Ribble Valley Borough Council
Council Offices
Church Walk,
Clitheroe
Lancashire
BB7 2RA

Phone: 0300 123 6780
Email: developeras@lancashire.gov.uk
Your ref: 3/2025/0981
Our ref: 3/2025/0981/HDC/KW
Date: 27 March 2026

Location: Former White Bull Hotel 257 Preston Road Longridge PR3 3BJ
Proposal: Conversion of a Former Public House to provide 3.no Dwellings to include the creation of new access points, landscaping, demolition of single storey rear extensions and erection of new single storey rear extension and window/door alterations and additions.
Grid Ref: 360020 435294

7074 - S02B

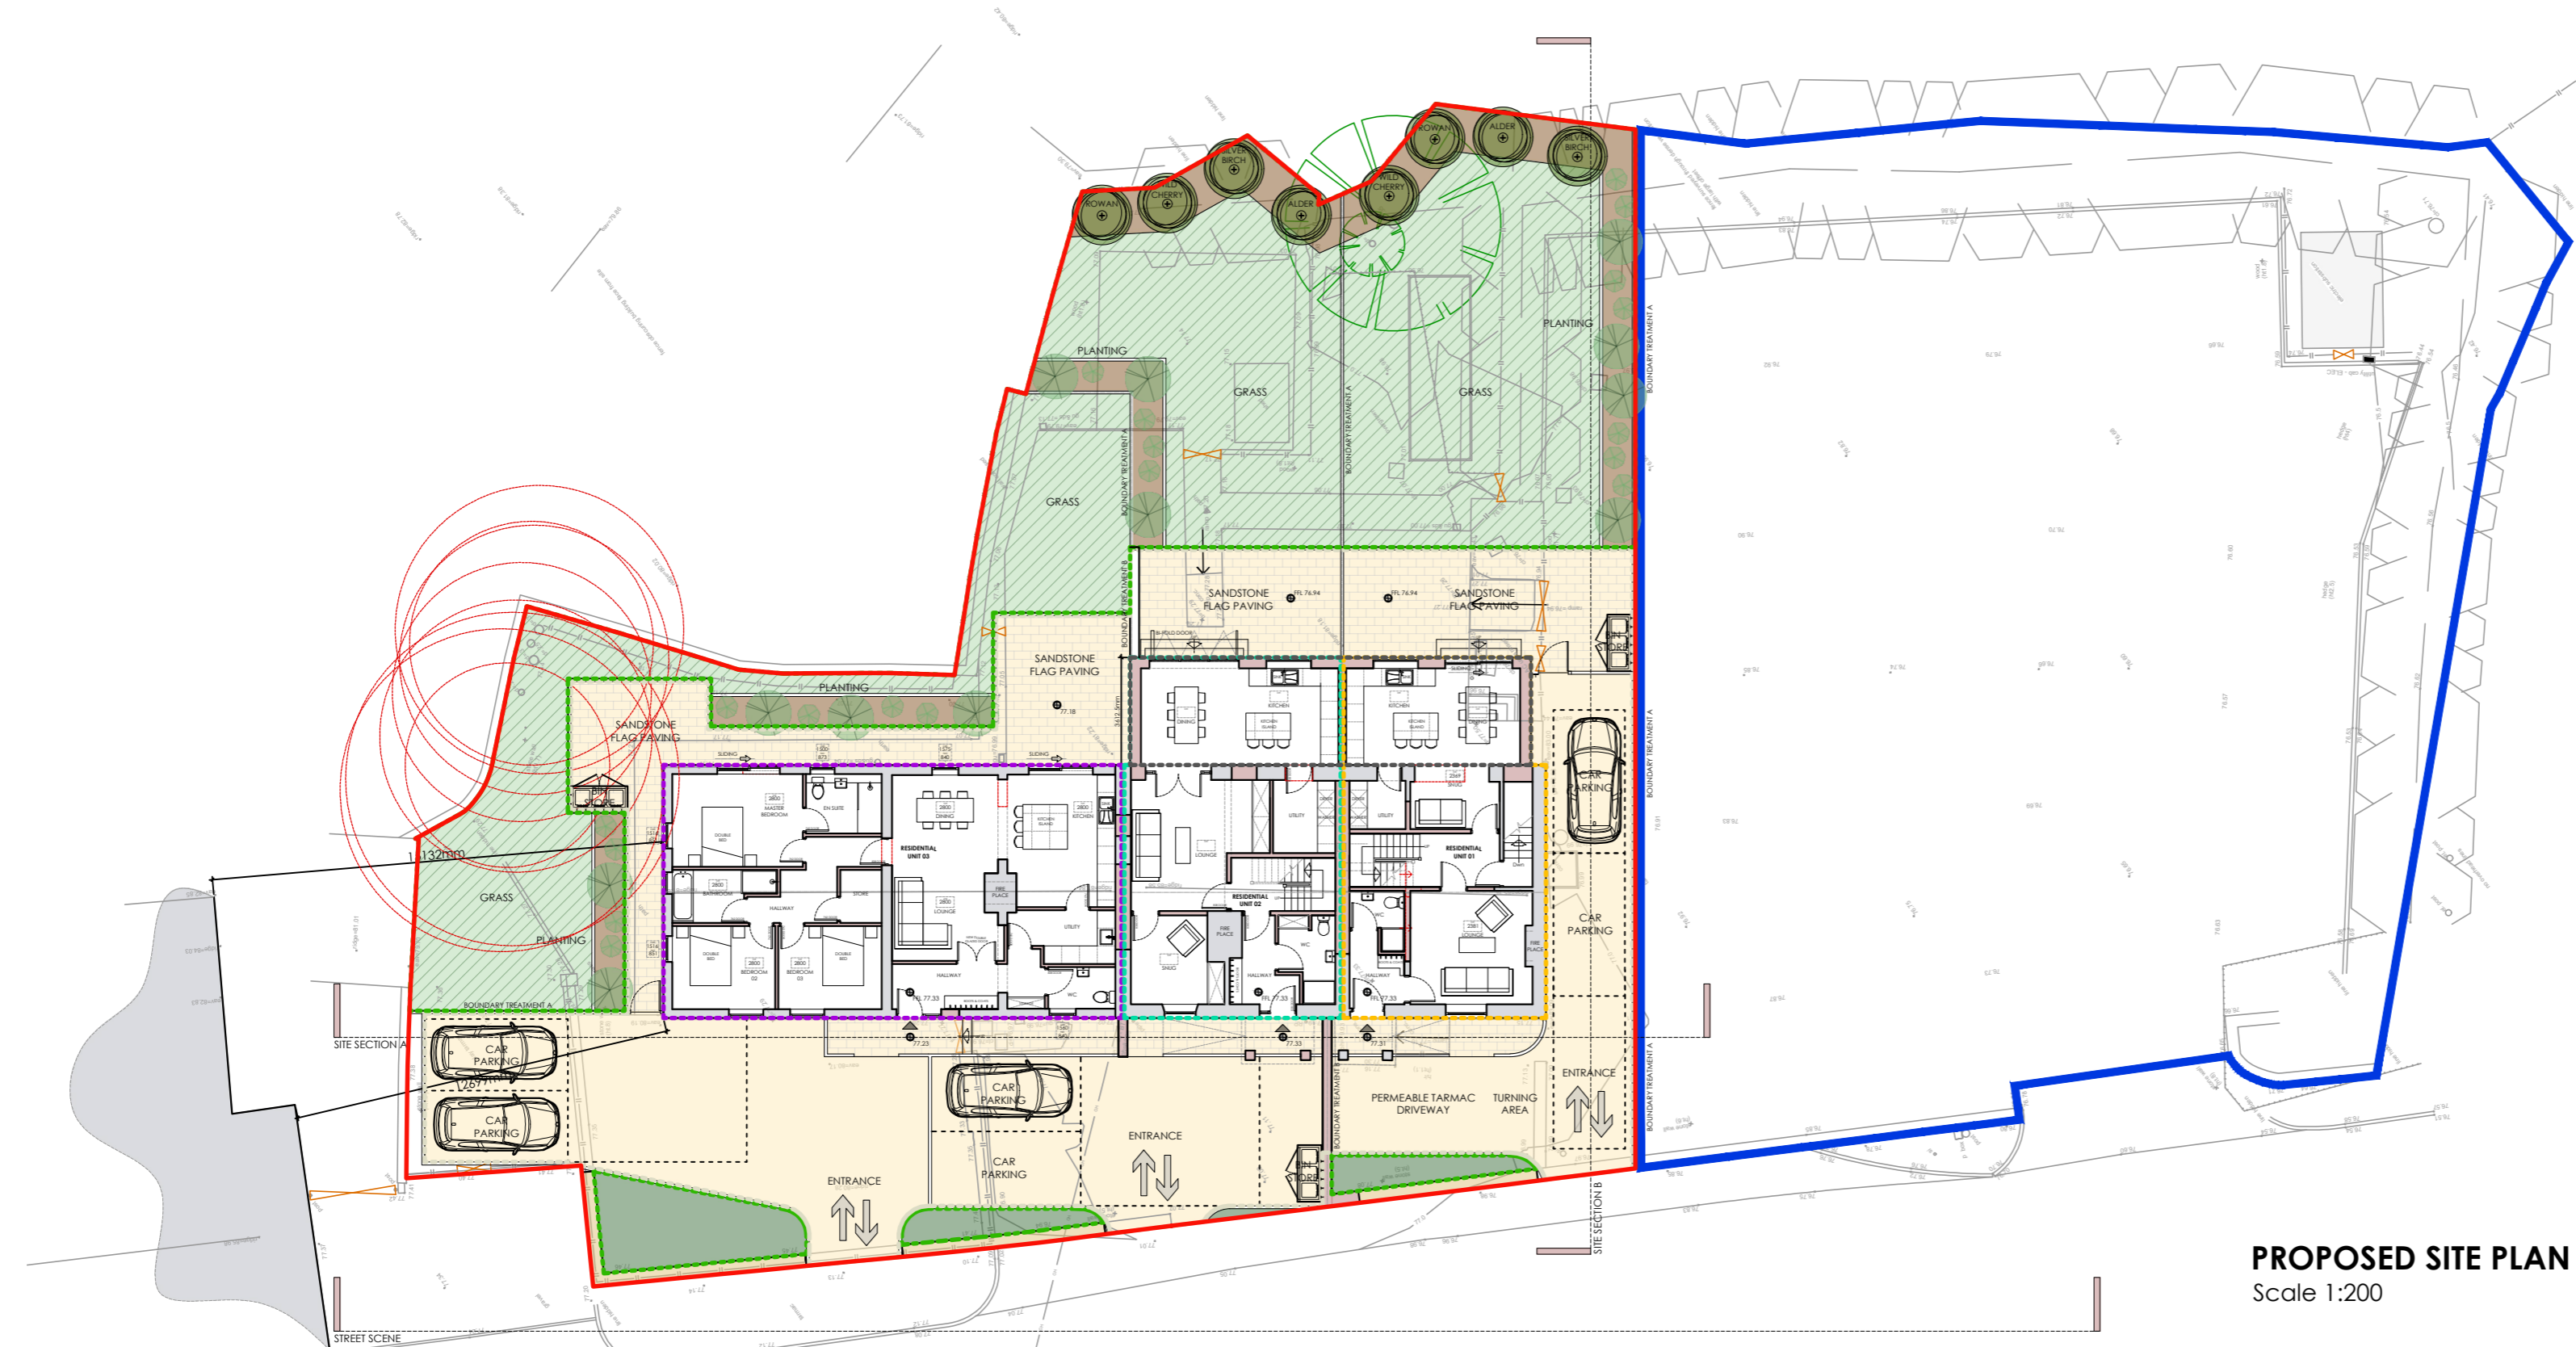
2. No part of the development hereby permitted shall be occupied until such time as the access arrangements shown on drawing number 7074 S02E have been implemented in full.
